Please ask for: Sian Eggington
Email: sian.eggington@terraquest.co.uk
Telephone: 0121 2341390
Our Ref: AB/126/20/HH
Your Ref:
Date: 19th November 2020

Application for Planning Permission for Works or Extension to a Dwelling

Development: 2 storey rear extension
Replacement windows
Replacement cladding
Infill to side void
Location: 38 Dalloway Road Arundel BN18 9HW

BLOCK PLAN

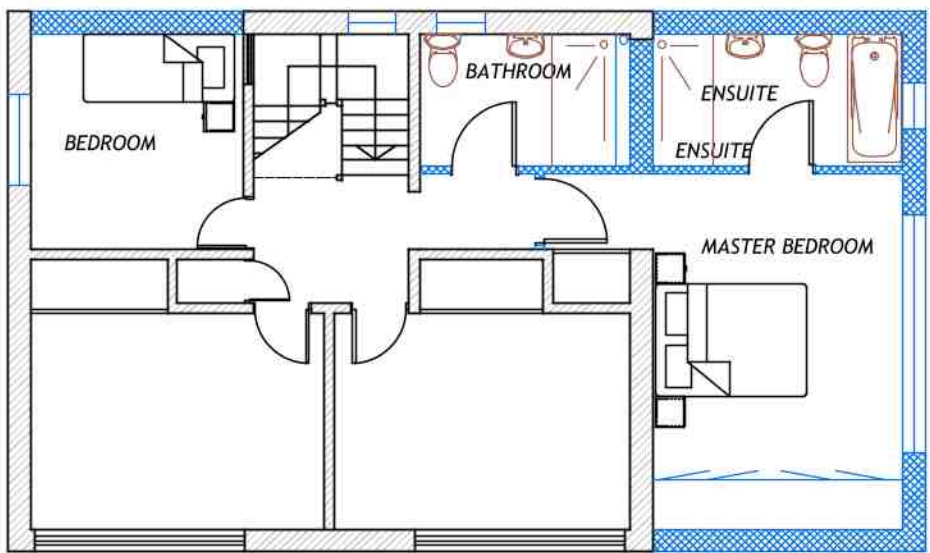
Dimension: You are required to submit dimensions on the block plan from the proposed extension to all site boundaries.
